# CITY OF ALBUQUERQUE

May 27, 2015

RE: **SAD 228 Residence**  
**6601 Cuervo PL NW**  
**Grading and Drainage Plan**  
**Engineers Stamp Date 5/11/15 (D10D003J7)**

SITE PLAN

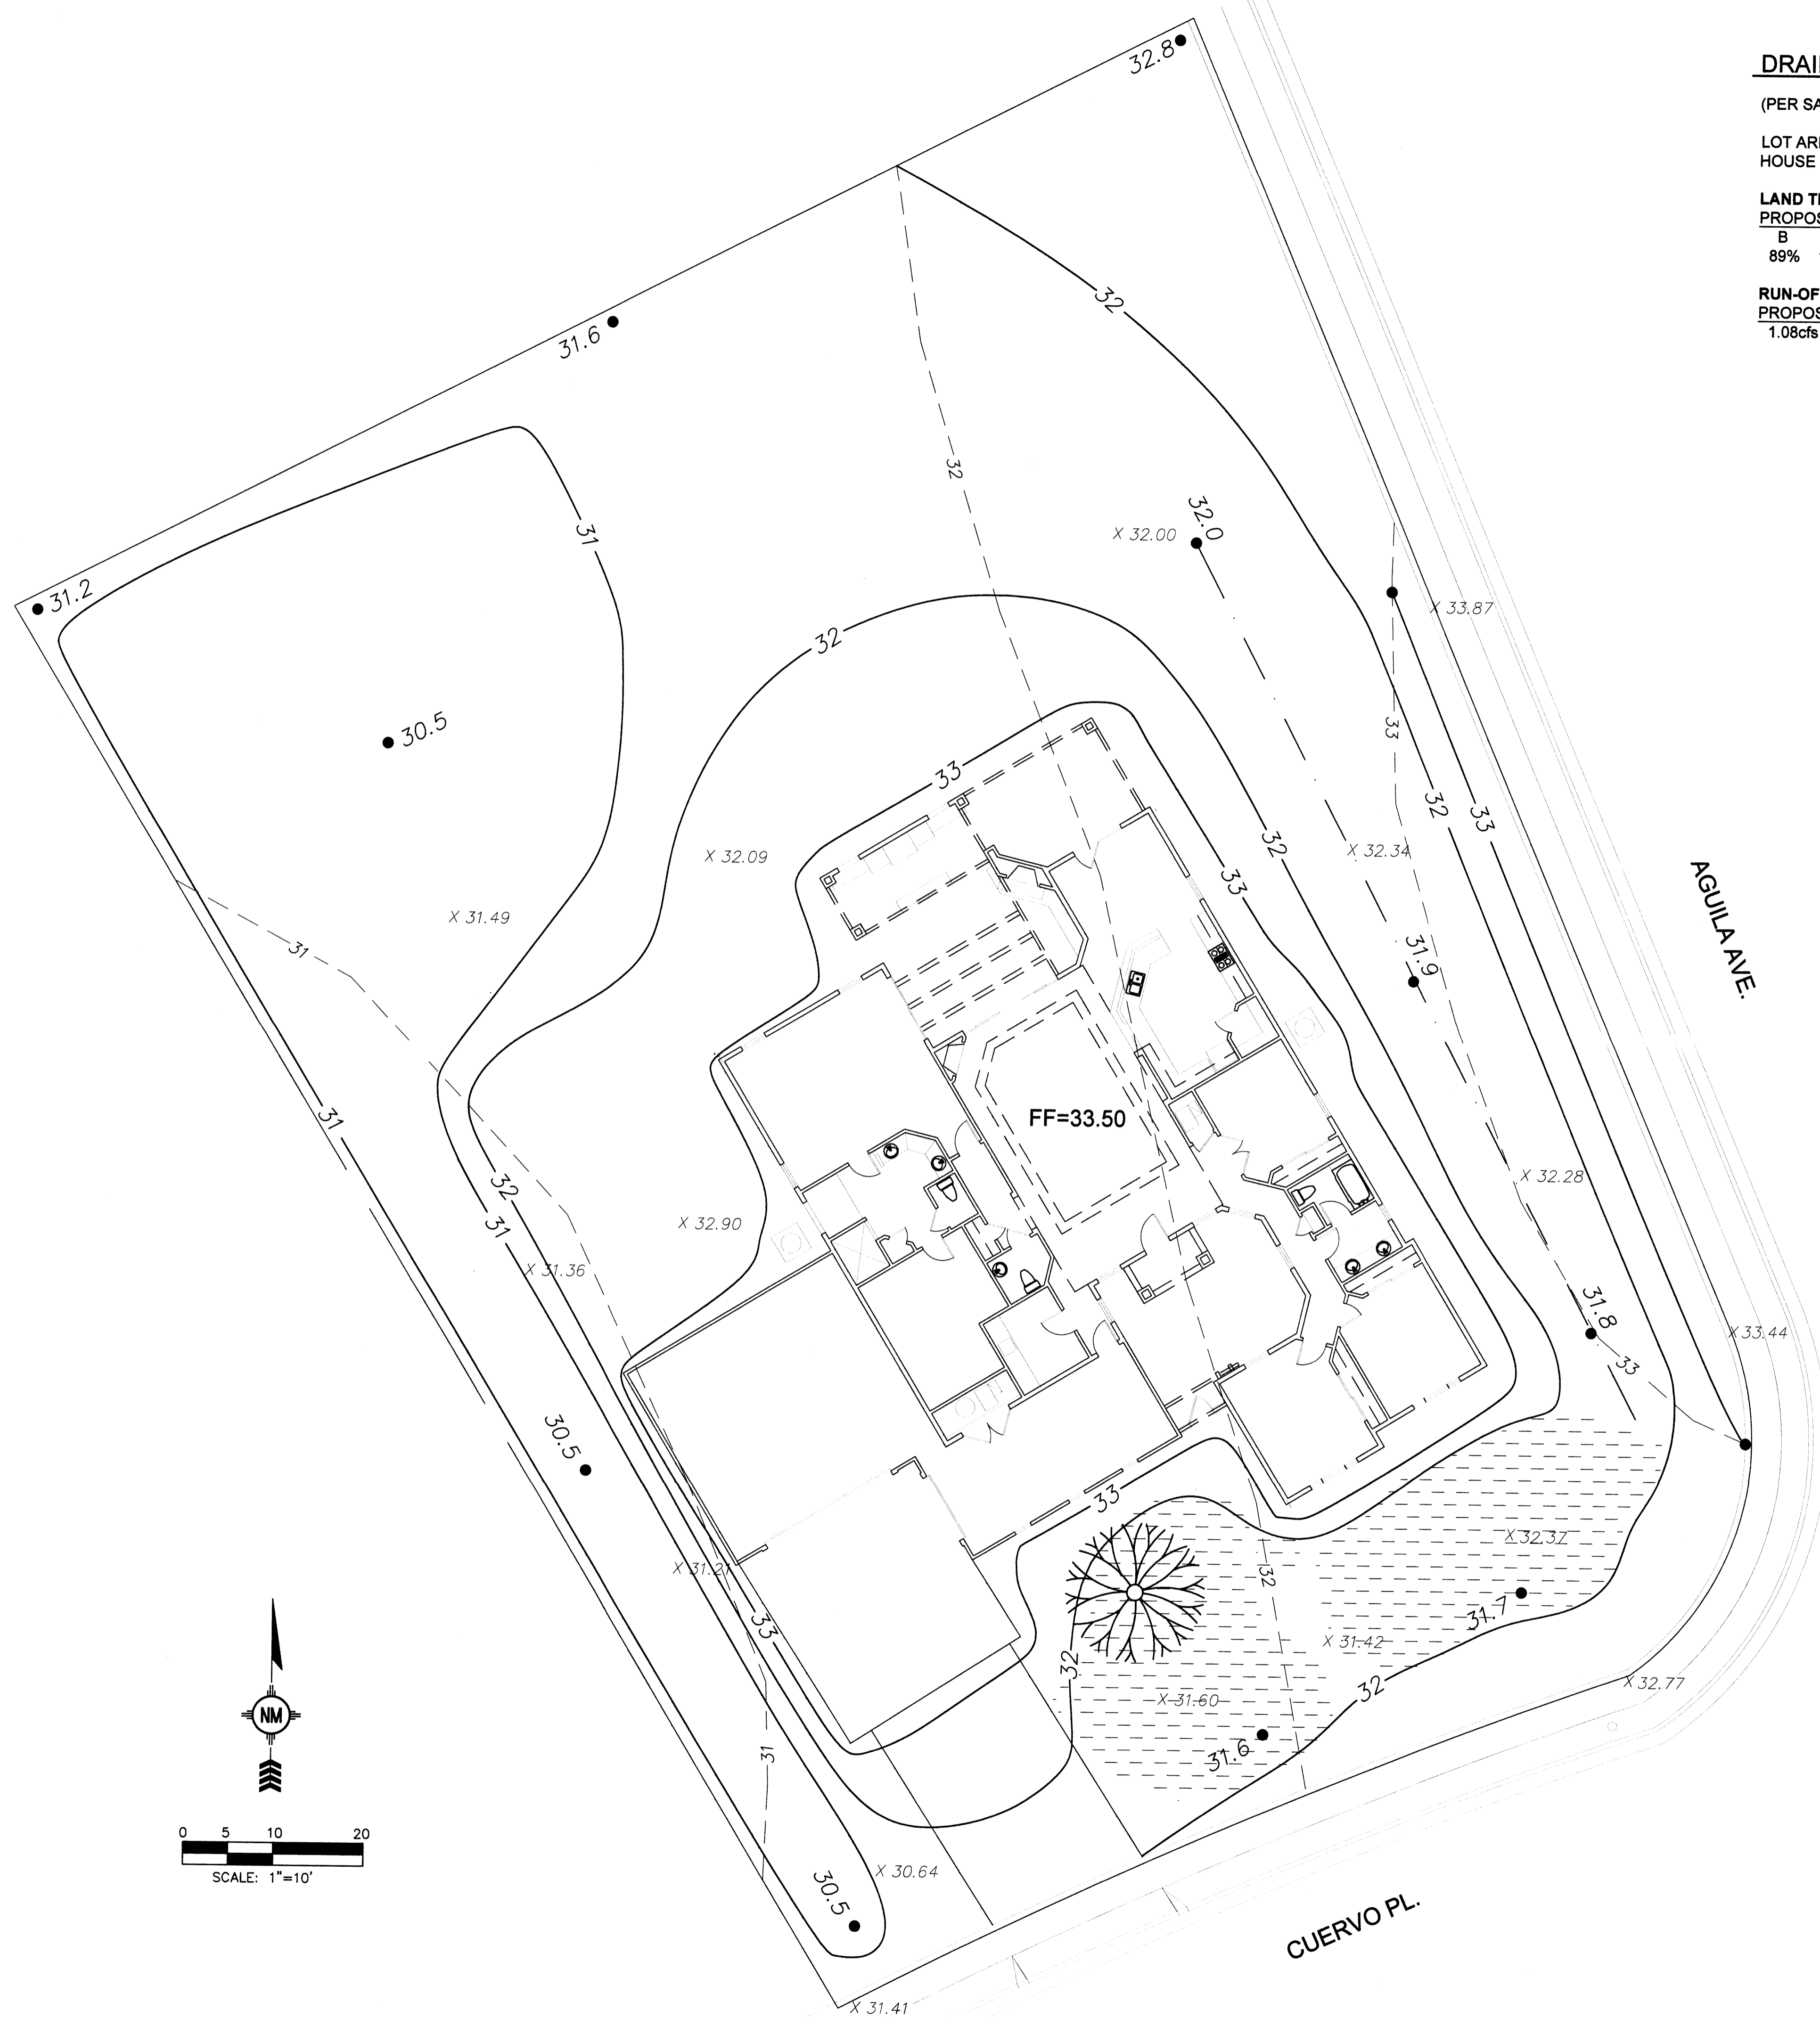
- Provide a site plan and FIRMette of this location.
- Provide a table of calculations for land treatments, percentages, existing and proposed flows.
- Provide a legal description of this site.
- Show or mention the location of the bench mark.
